From: Sarah Burrow <Sarah.Burrow@arun.gov.uk>
Sent: 05 August 2021 16:10
To: Planning.Responses <Planning.Responses@arun.gov.uk>
Cc: Maria Tomalova <Maria.Tomalova@arun.gov.uk>
Subject: RE: Planning Consultation on: BN/95/21/DOC

Engineers Comments Regarding Surface Water Drainage

Application No: BN/95/21/DOC

Description of Works: Approval of details reserved by condition imposed under BN/39/19/PL relating to conditions 3-schedule of materials and finishes & 6-surface water drainage scheme.

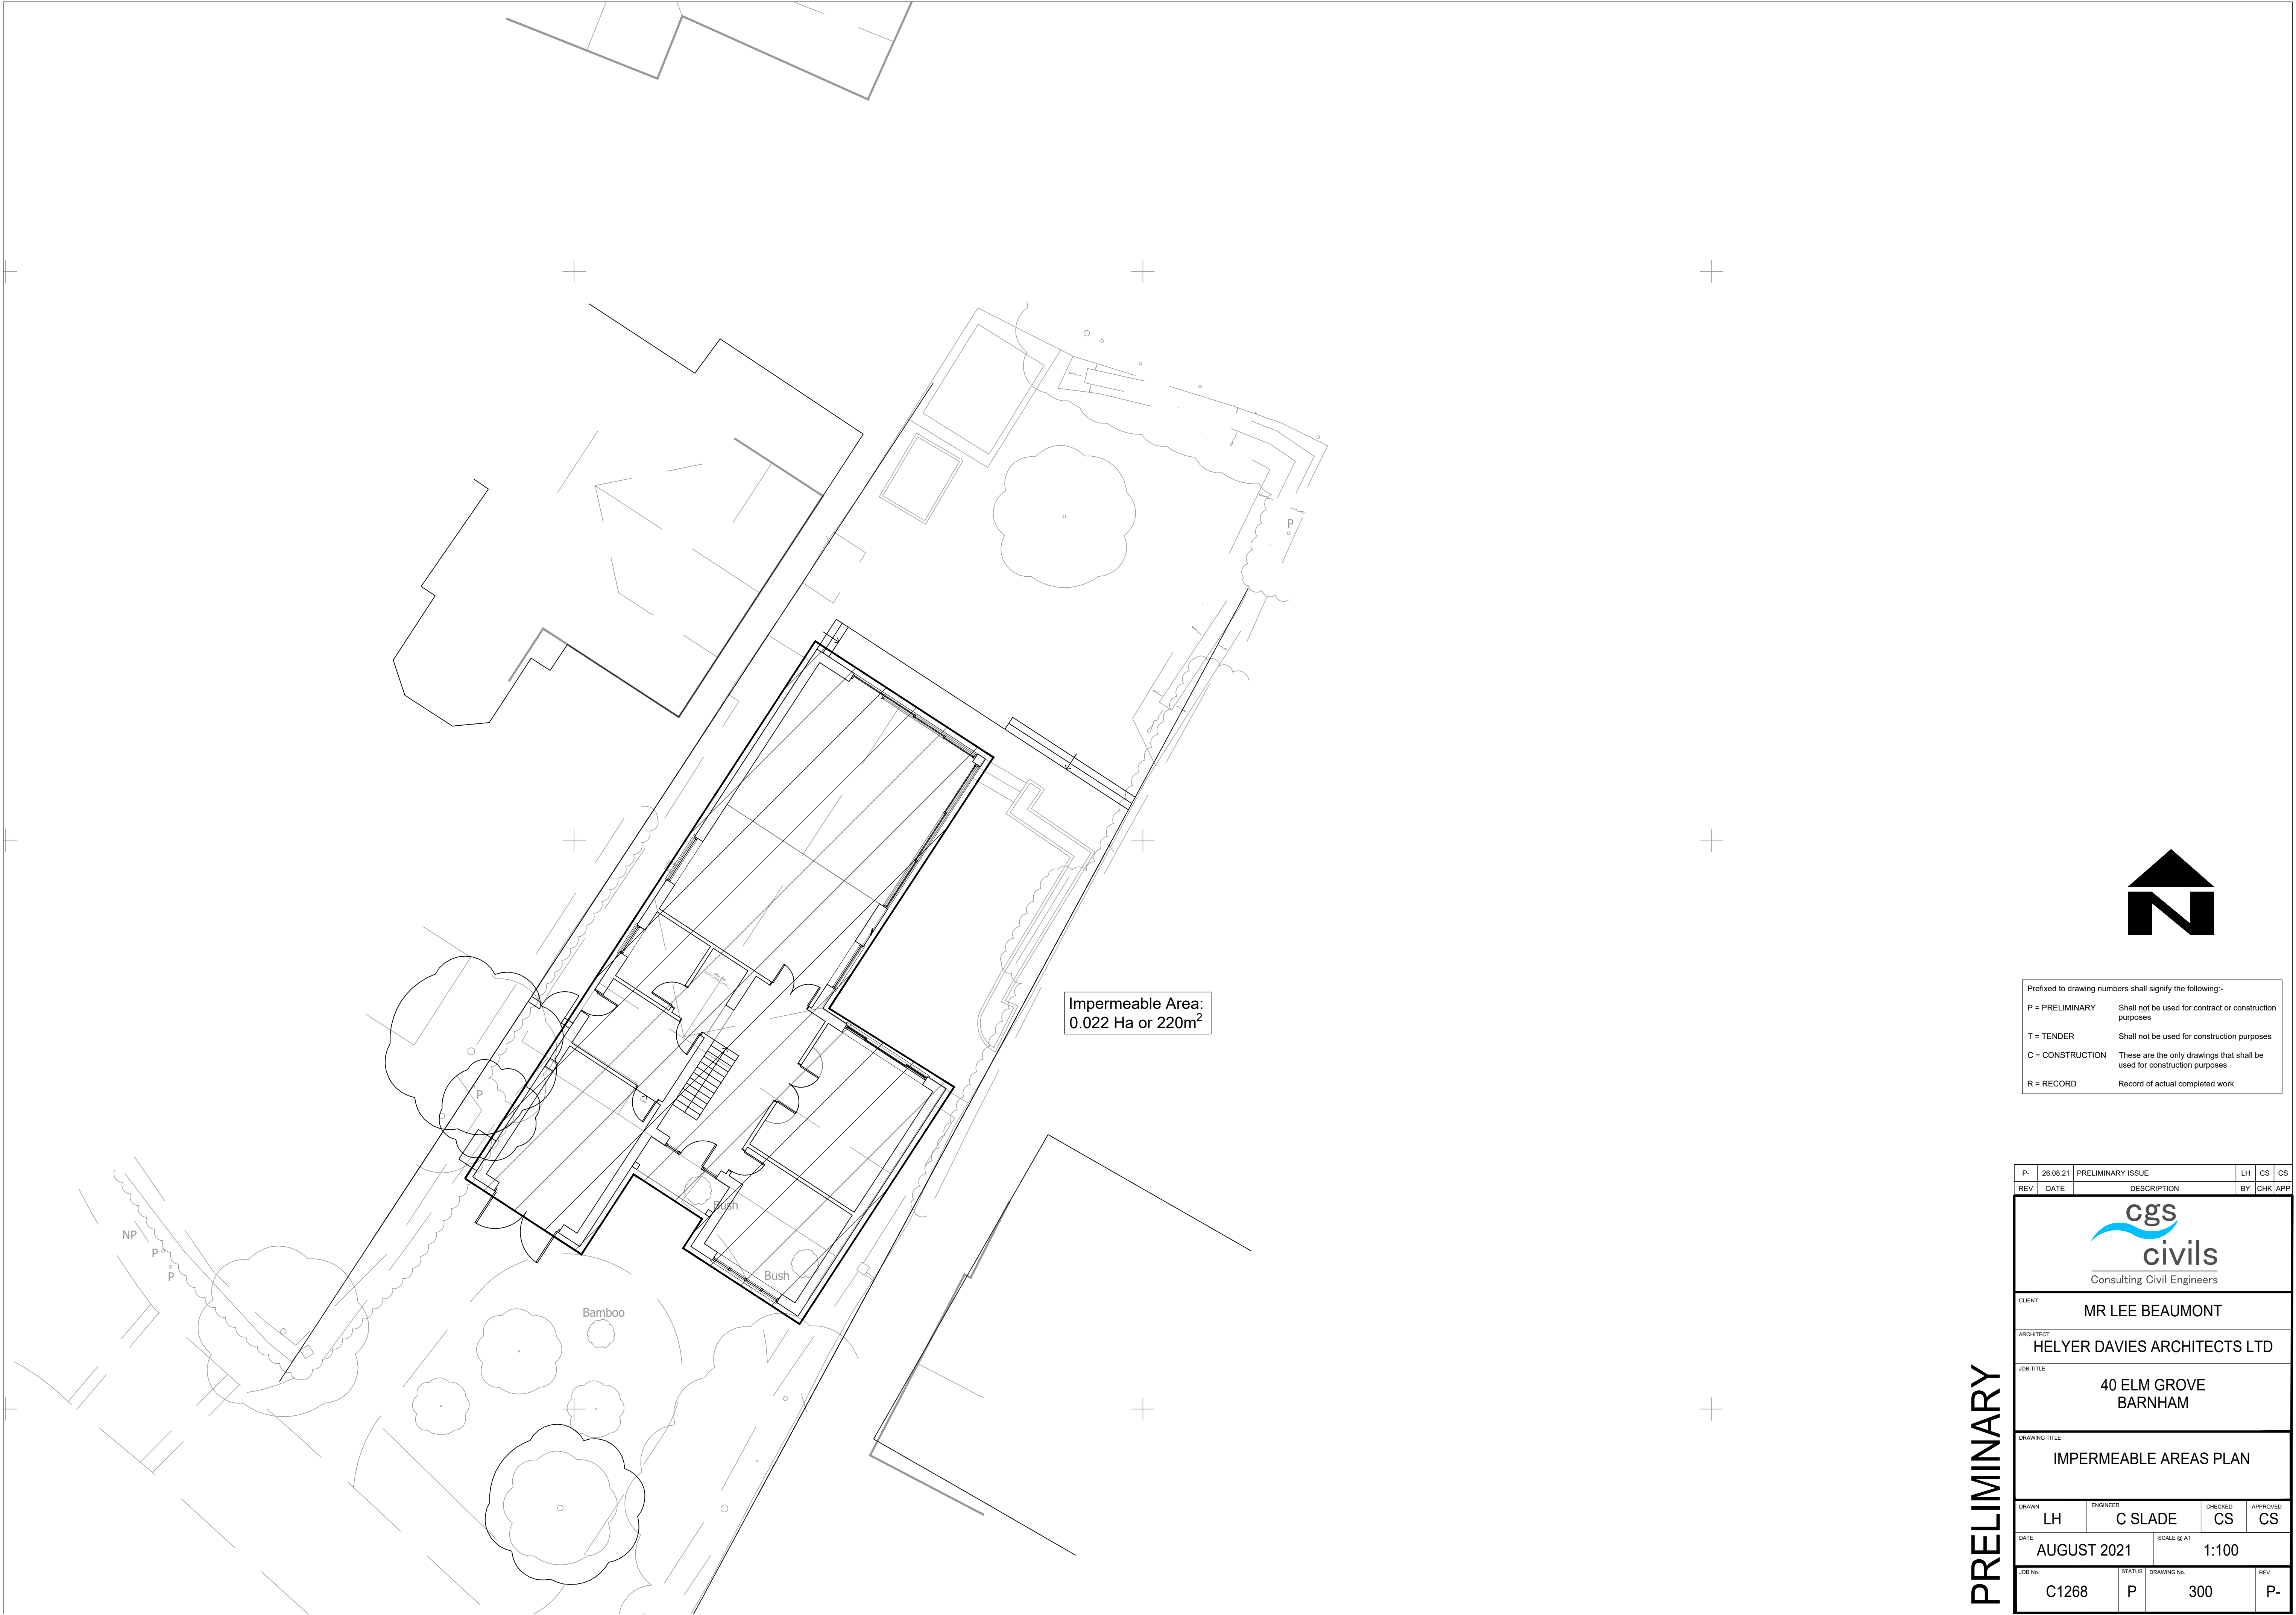
1. Please can you confirm the impermeable area used for the calculations. We would normally expect an impermeable area plan, however noting this on the layout should be sufficient as it is the whole dwelling.
2. Please can you adjust the pipe junctions on the western side of the dwelling so that they are angled in the direction of flow. Please also include a detail of the pipe junctions.
